Arun District Conservation Area Advisory Panel
c/o Civic Centre

22nd February 2021

Application No: AB/7/21/L
Site Address: Vyne Cottage 33 Mount Pleasant Arundel BN18 9BD
Description of works: Listed building consent for the replacement of 12 No. windows & 1 No door.

Drawing Title:
Proposed Elevations

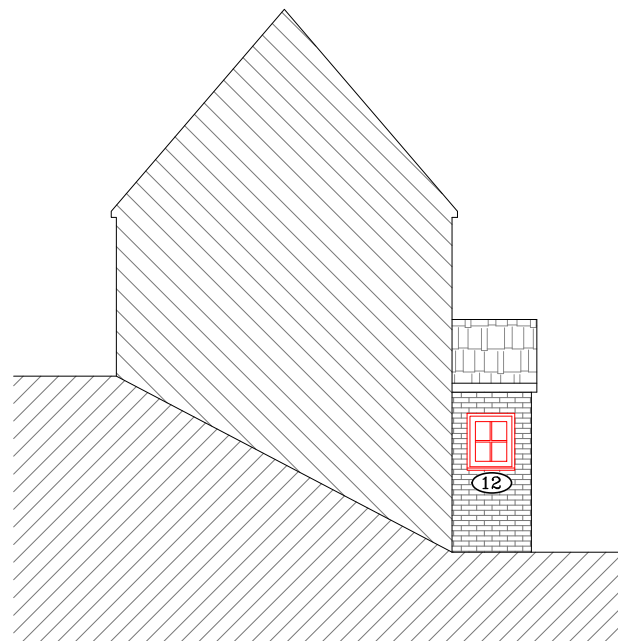
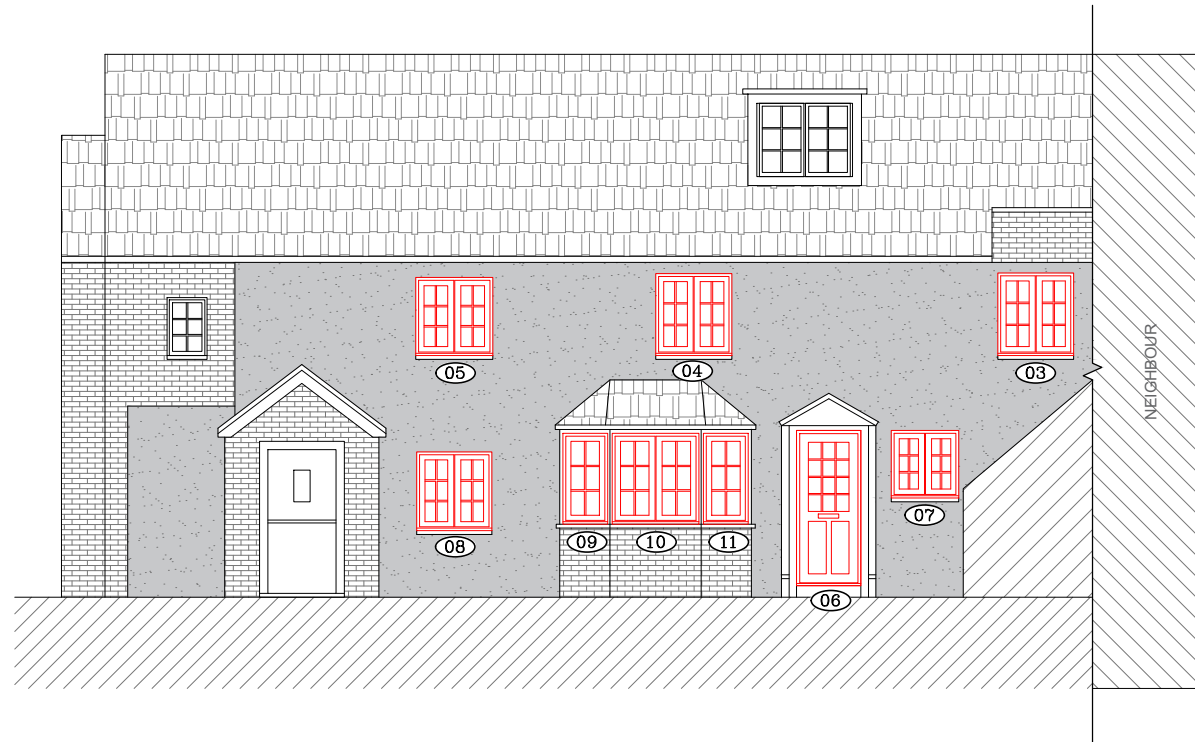
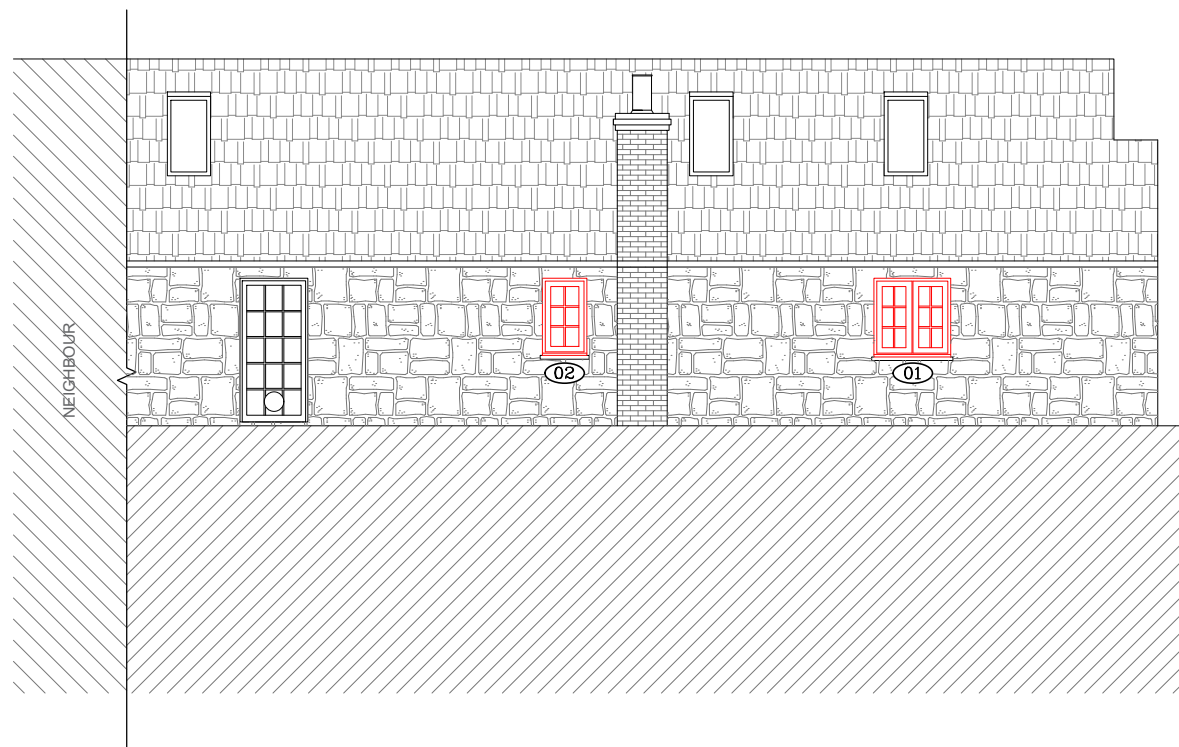
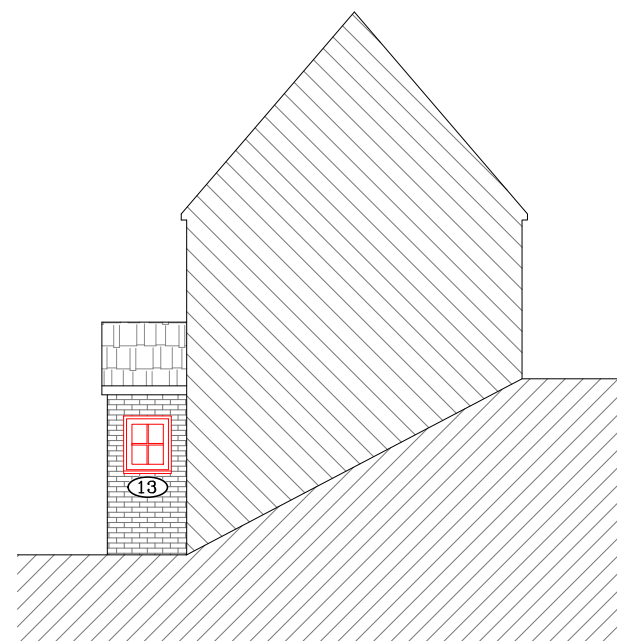
The proposal is to replace the existing windows with timber side hung casements but with standard double glazed units with what appears to be 'stick on' glazing bars.

There will be an unfortunate difference in appearance with the new windows particularly due to the increase in depth to the glazing units, the dead flat appearance to the glass and the use of thermal spacers. In terms of the effect on the character and appearance of the conservation area it is likely that the proposed works will sit in the lower end of less than substantial harm for the purposes of the NPPF.

The Advisory Panel is also concerned that if the windows currently shown in the application are granted listed building consent then it could well set a precedent for similar proposals in other historic buildings in the conservation area which over time will have a significantly adverse impact on its character and appearance.

Drawing Title:
Proposed Windows and Details

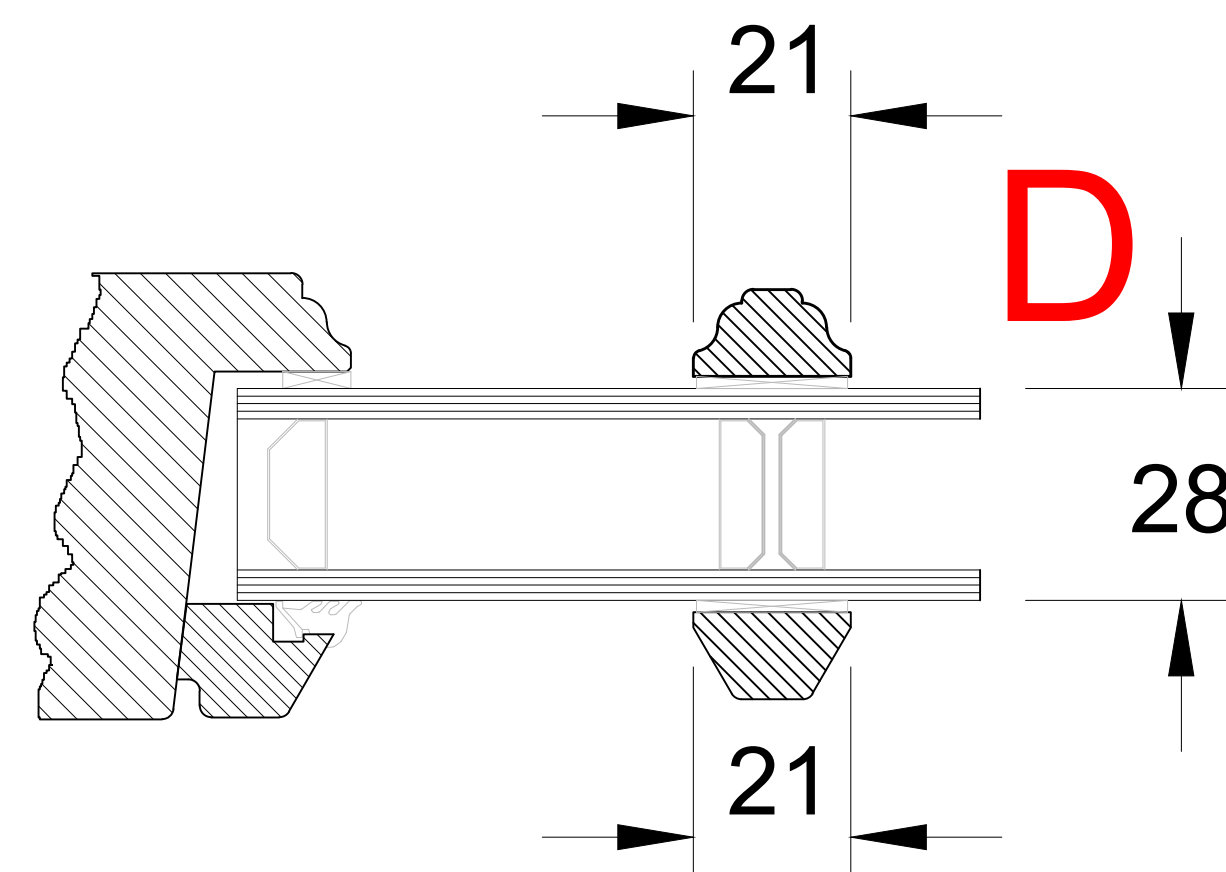
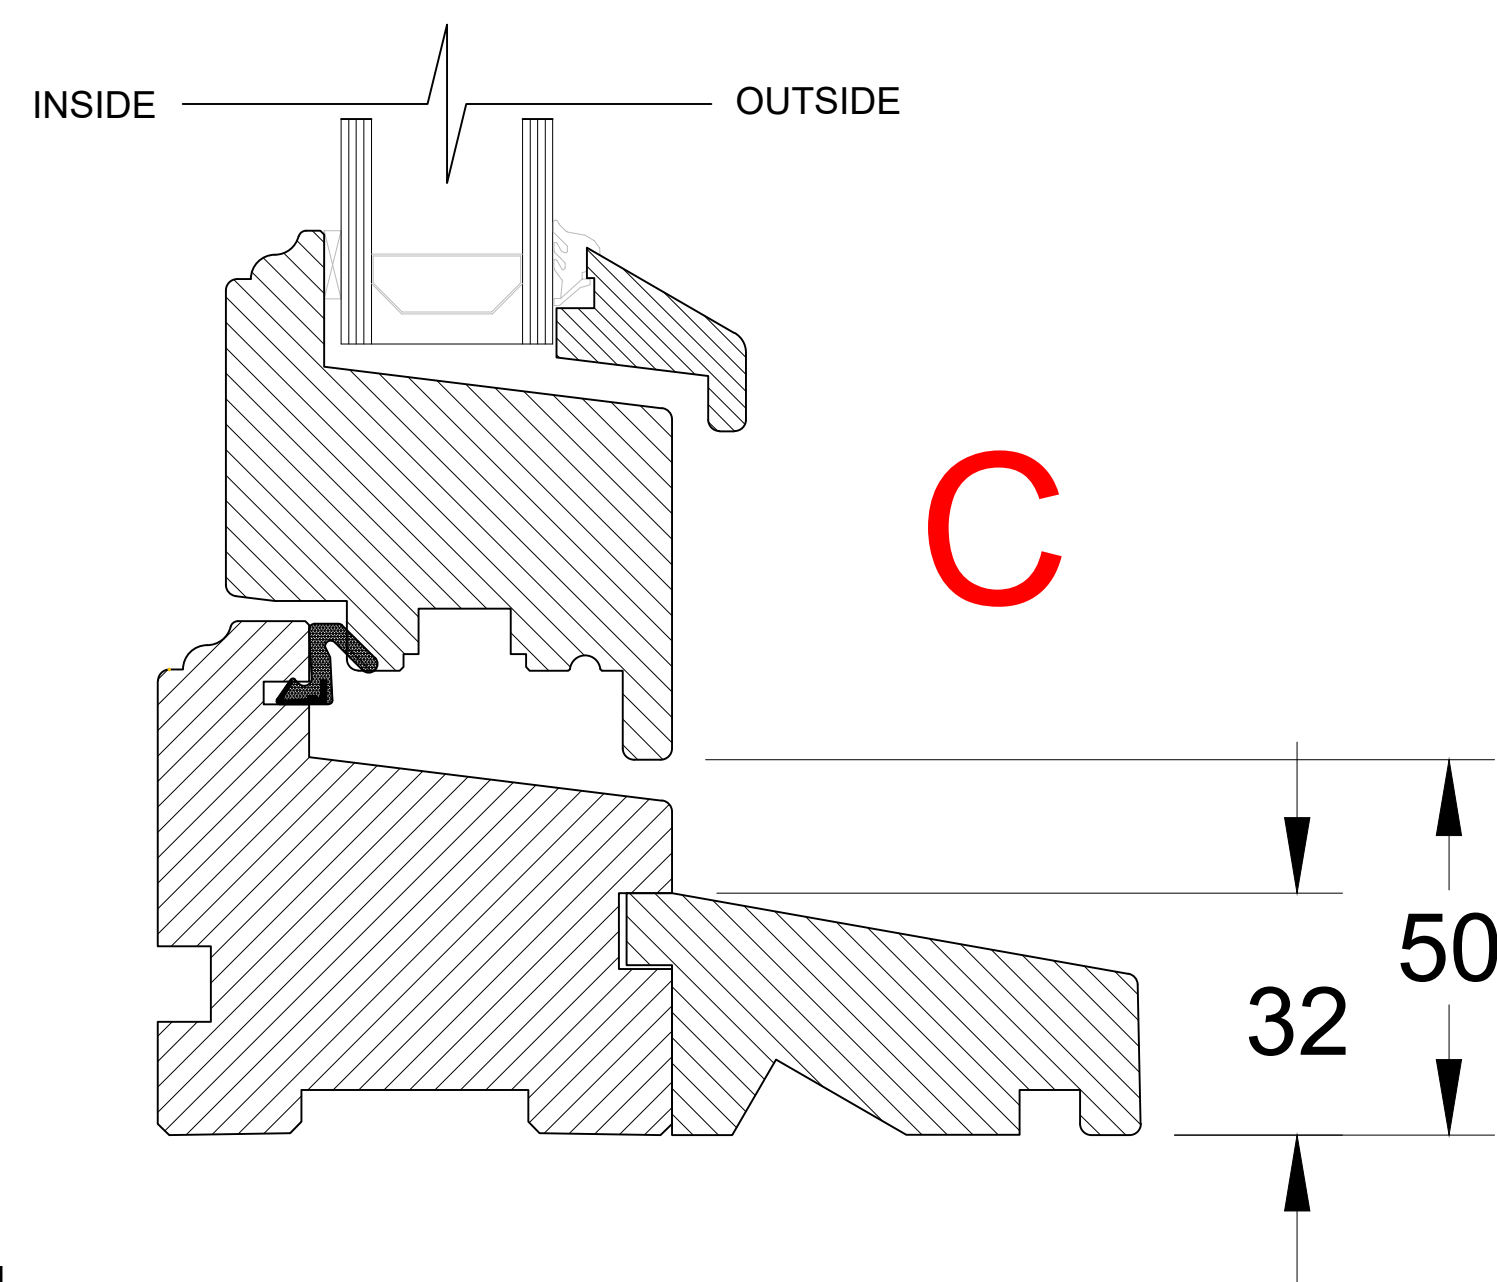
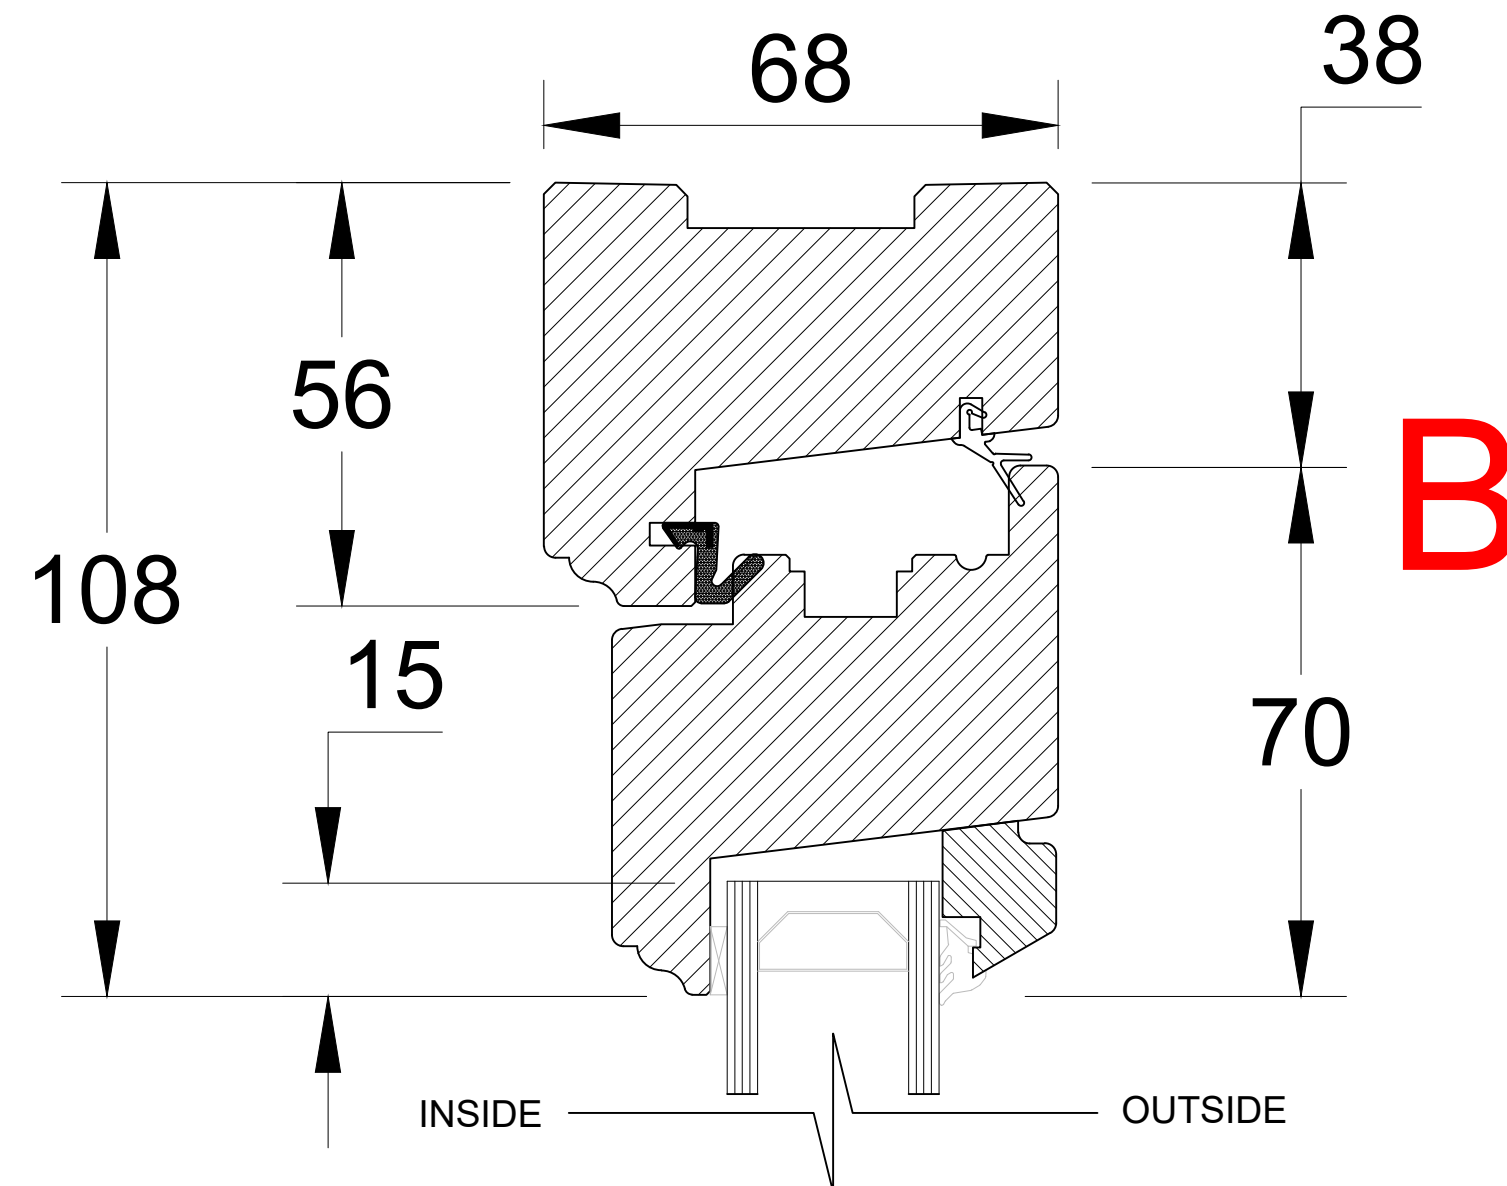
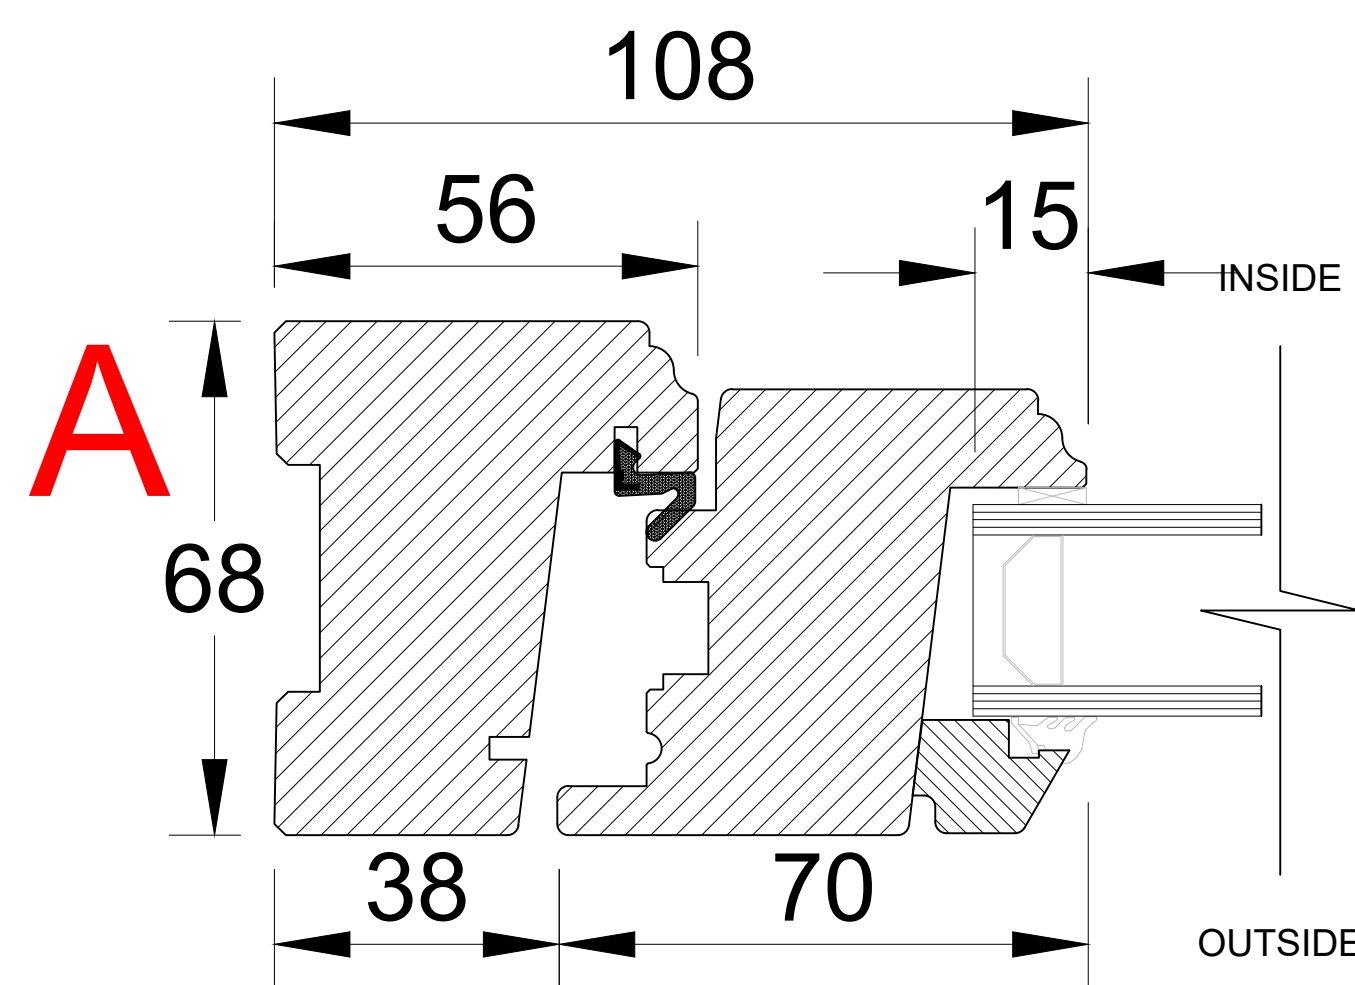
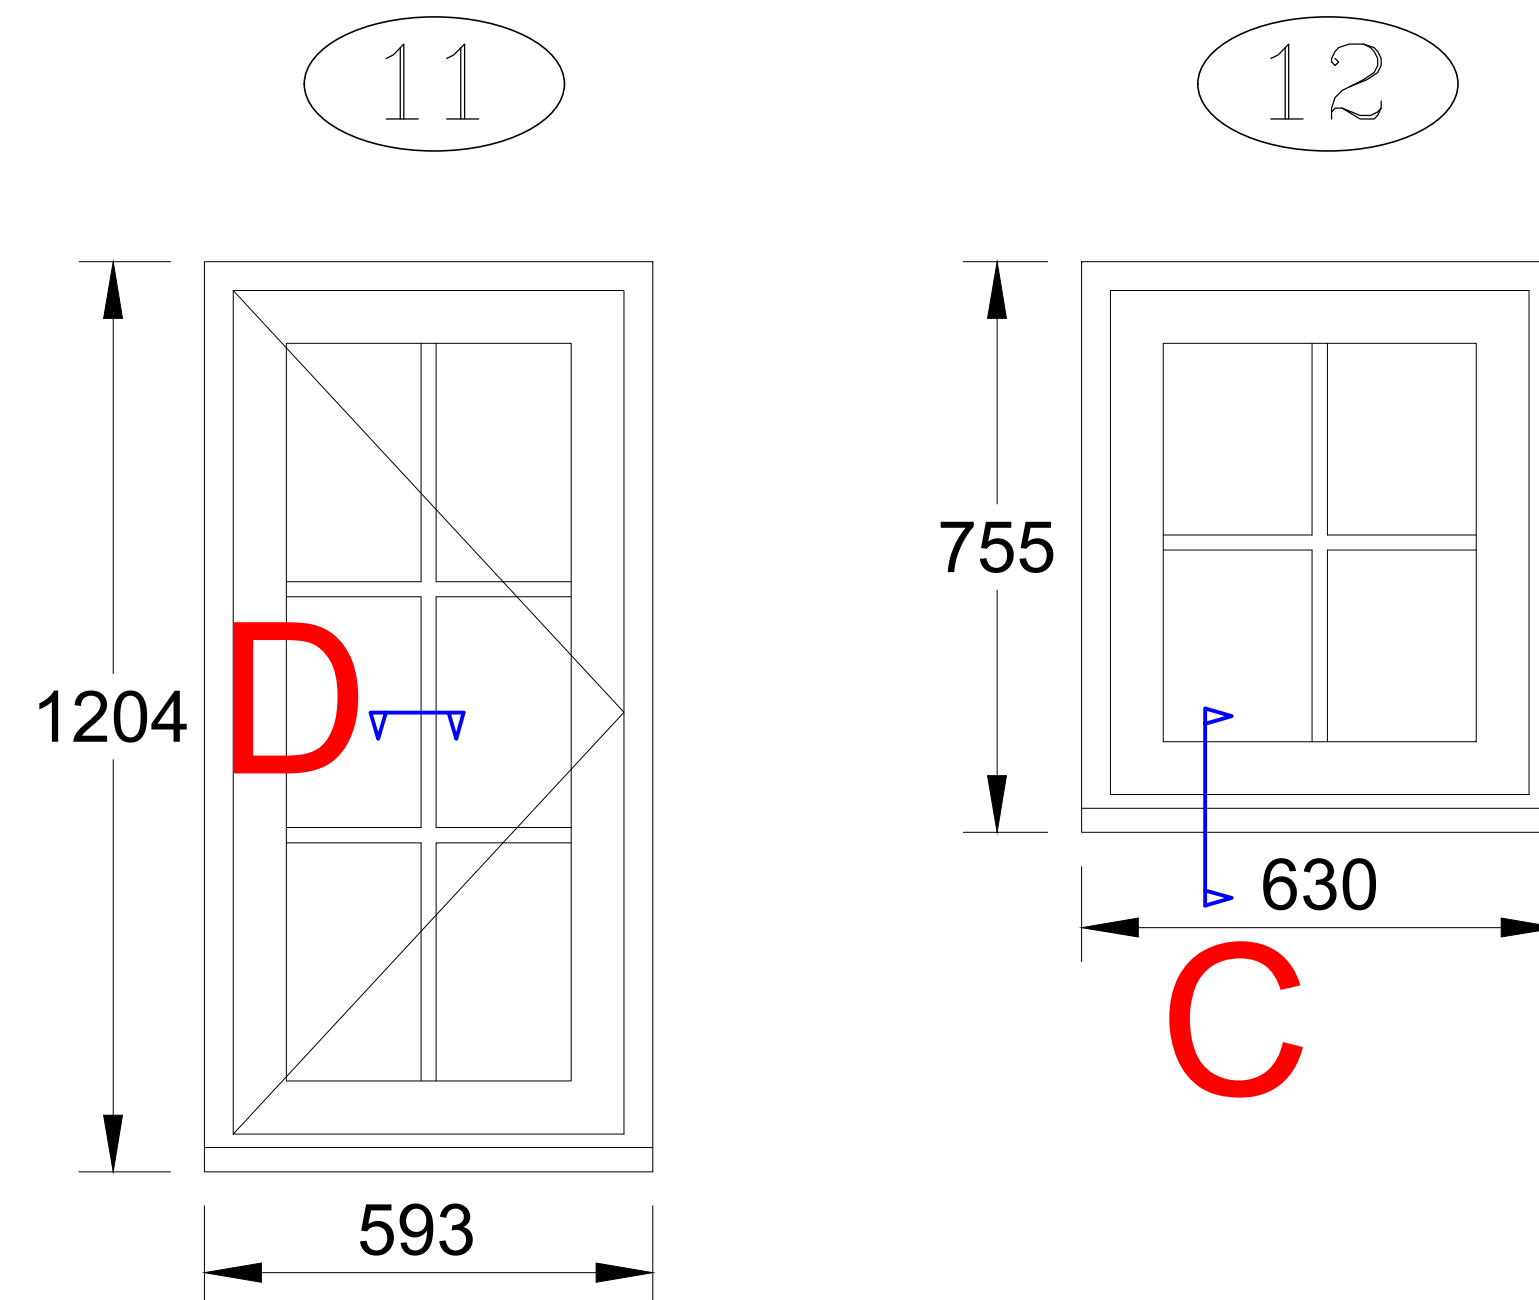
If the Council considers that, in this instance, there is a case for replacement painted timber double glazed windows then it is strongly recommended that they should incorporate slim profile glazing units of approximately 12mm depth and with the use of properly formed glazing bars.
